**NON-MATERIAL AMENDMENT APPLICATION UNDER SECTION 96A OF PLANNING PERMISSION  
20/0027/F**

132-136 Powis Street, Woolwich, London, SE18 6NL.

Amendment sought: Minor amendments to the Approved basement, and ground floor and front and rear elevations namely:

Proposed North Elevation (Rear)
PW 200 EL N
1:100 @ A3

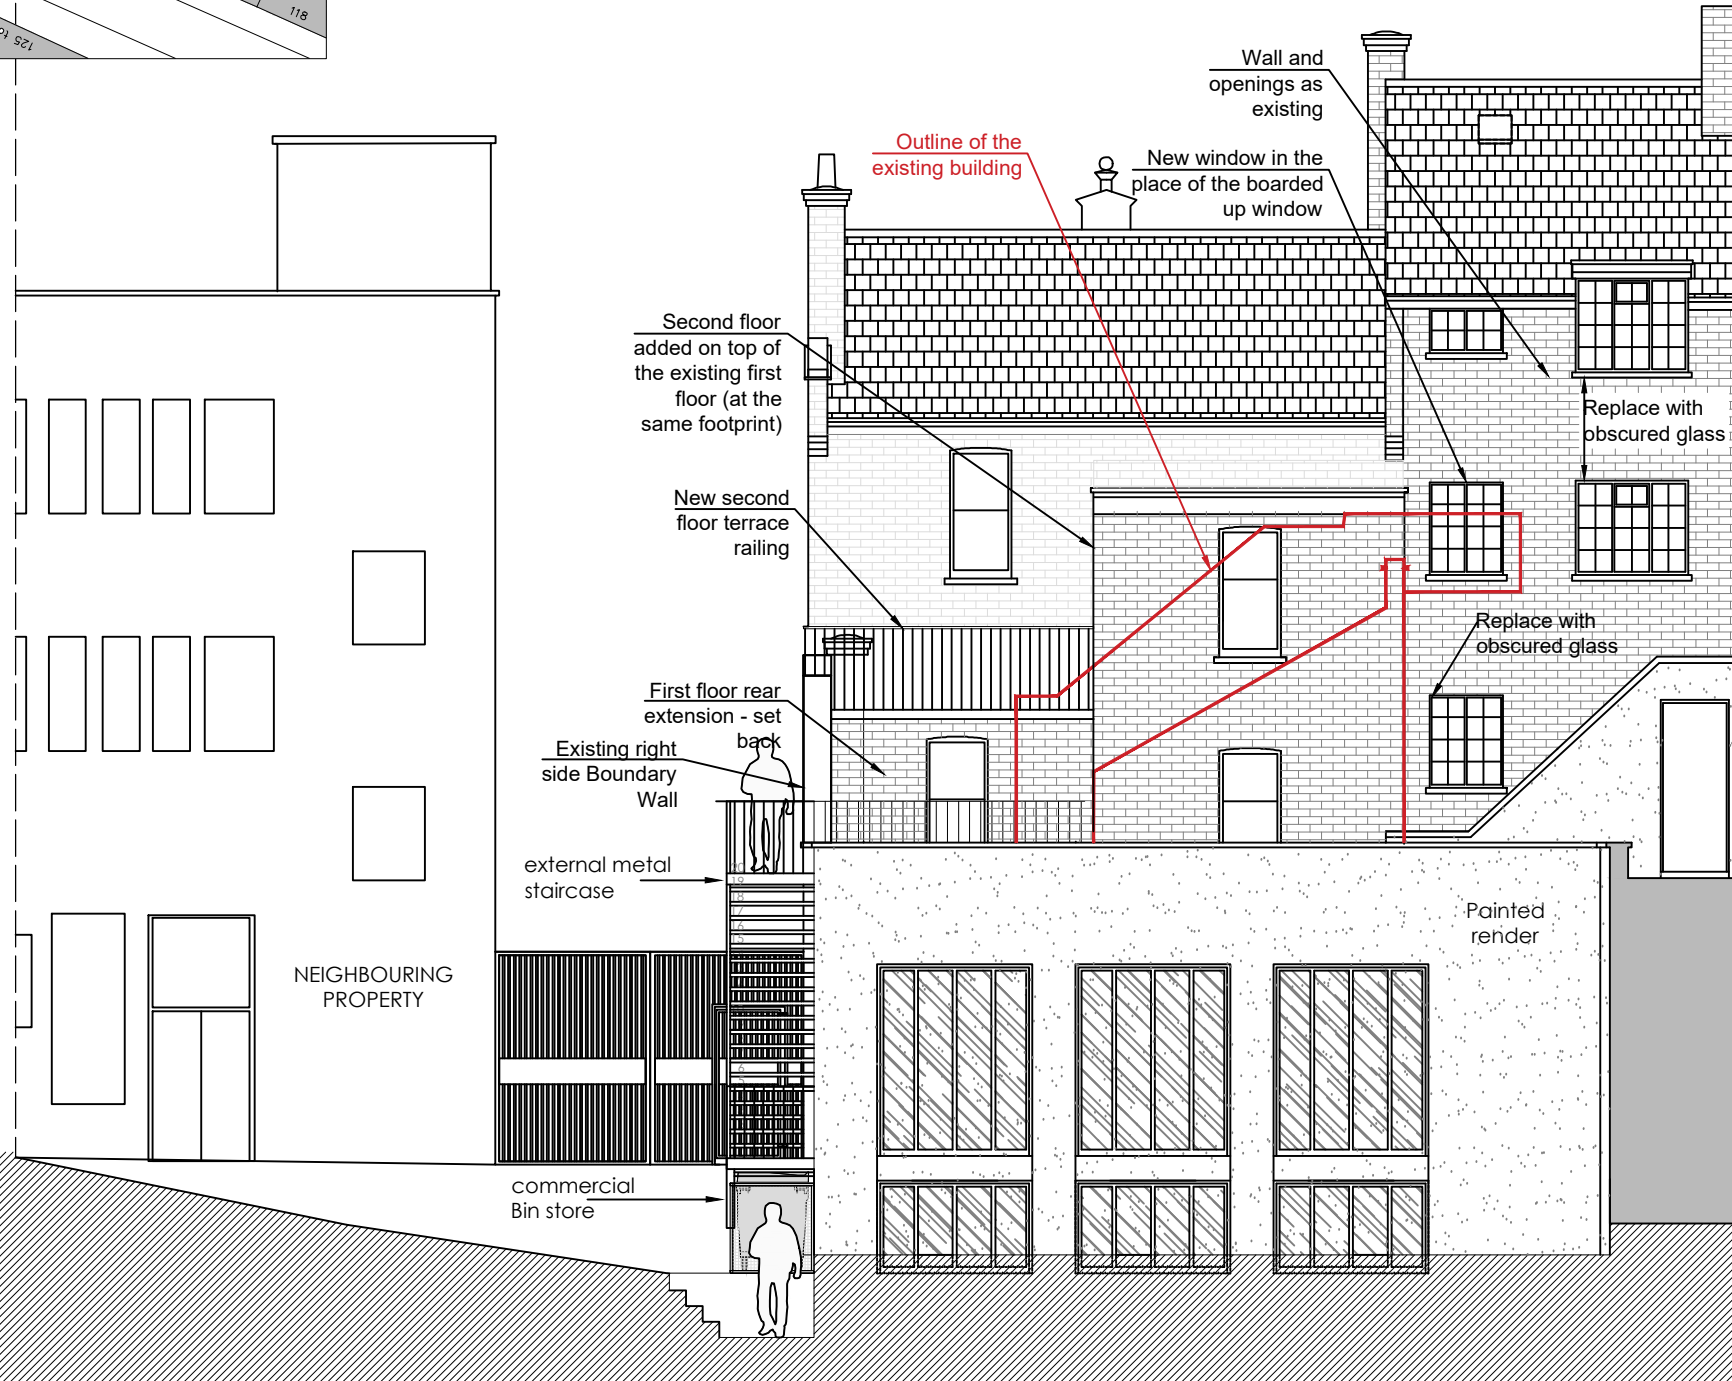
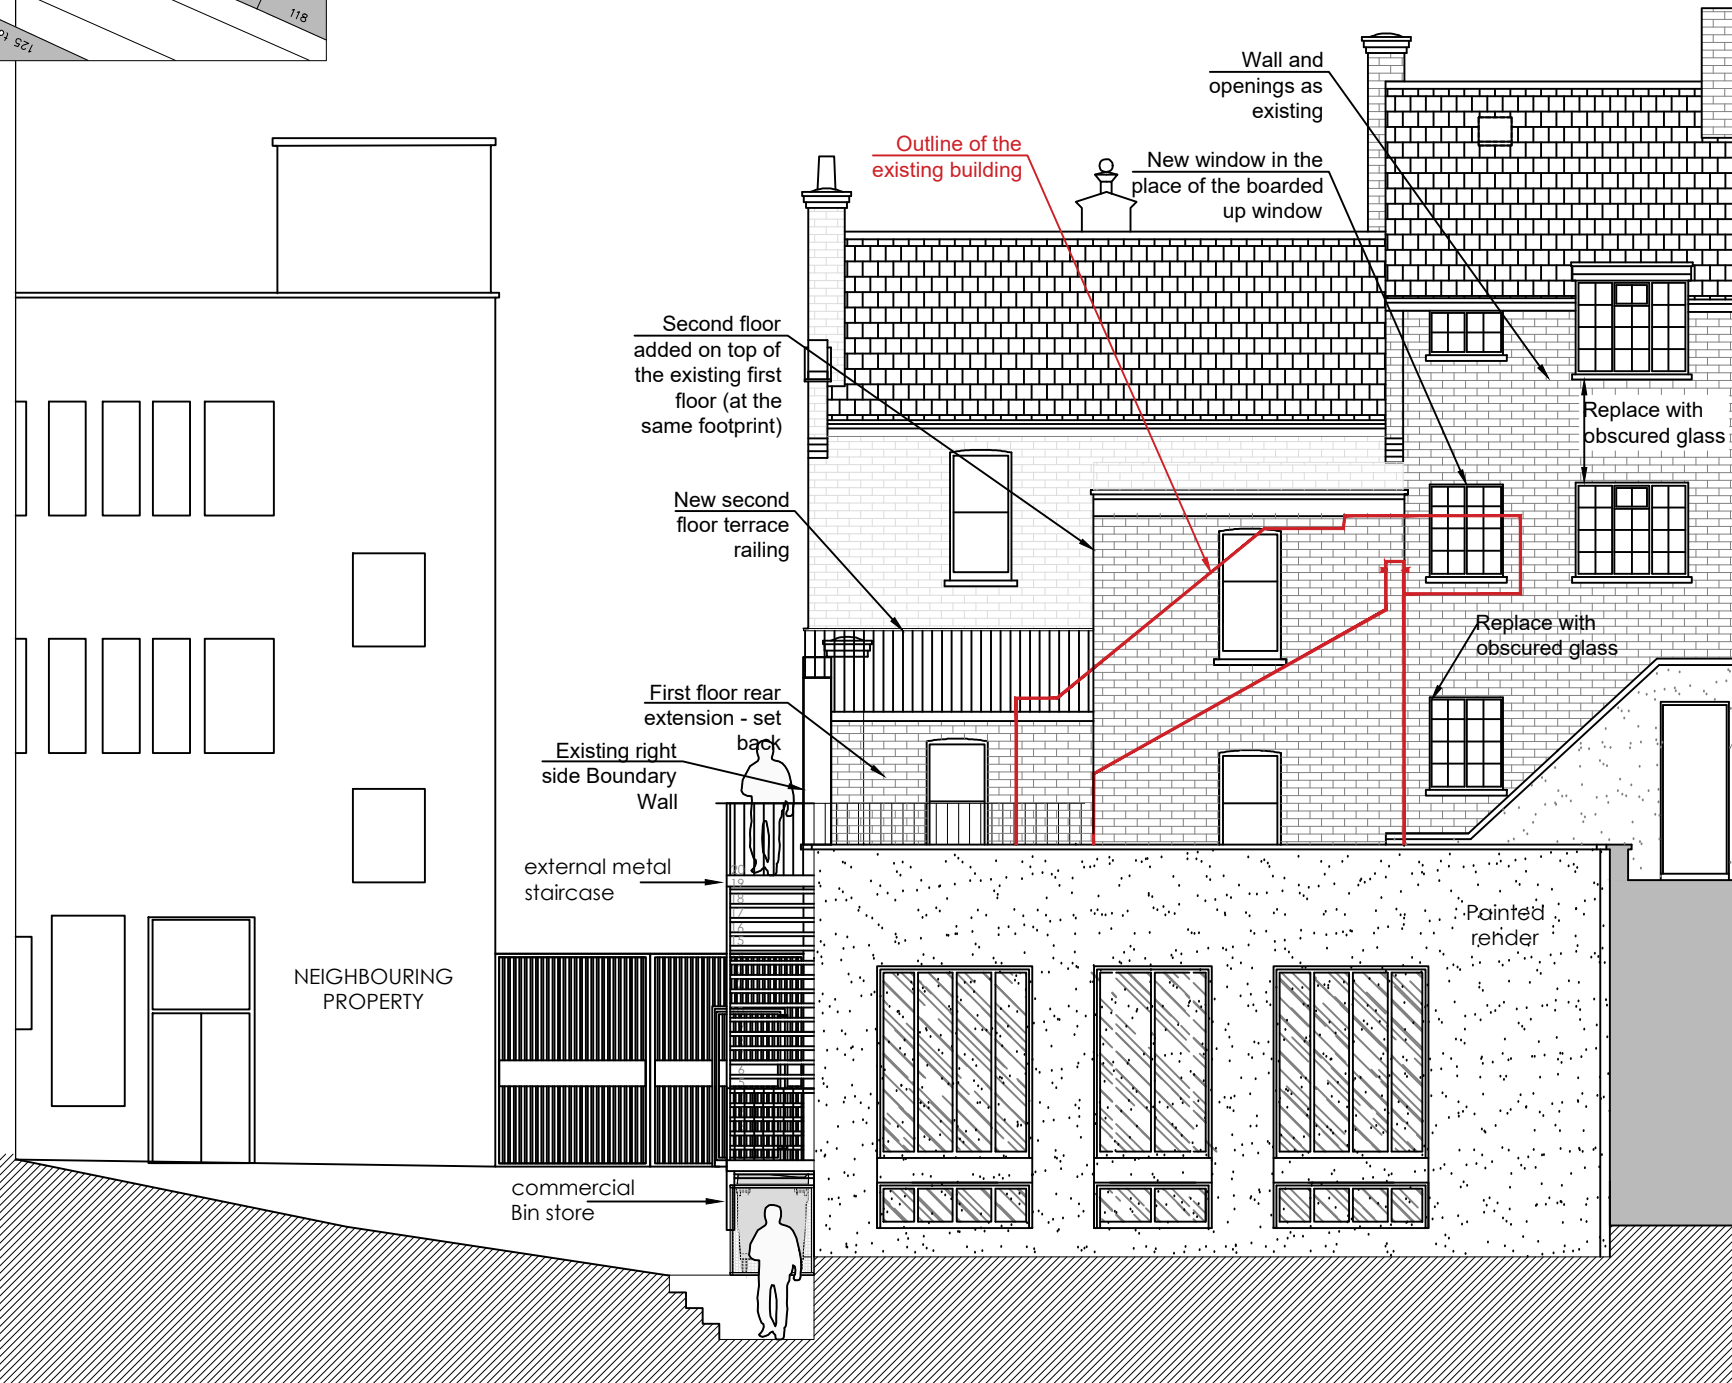
1. Few amendments on the basement layout, including the reduction of the size of the middle rear windows to retain as existing.

2. Few amendments on the ground floor layout for a better use of the space. It will also include the deduction of the size of one window at the rear to replicate the one in the basement.
3. Slight relocation of the bins at the front façade to facilitate the residential entrance to the upper's floors, which include a minor change to the façade.
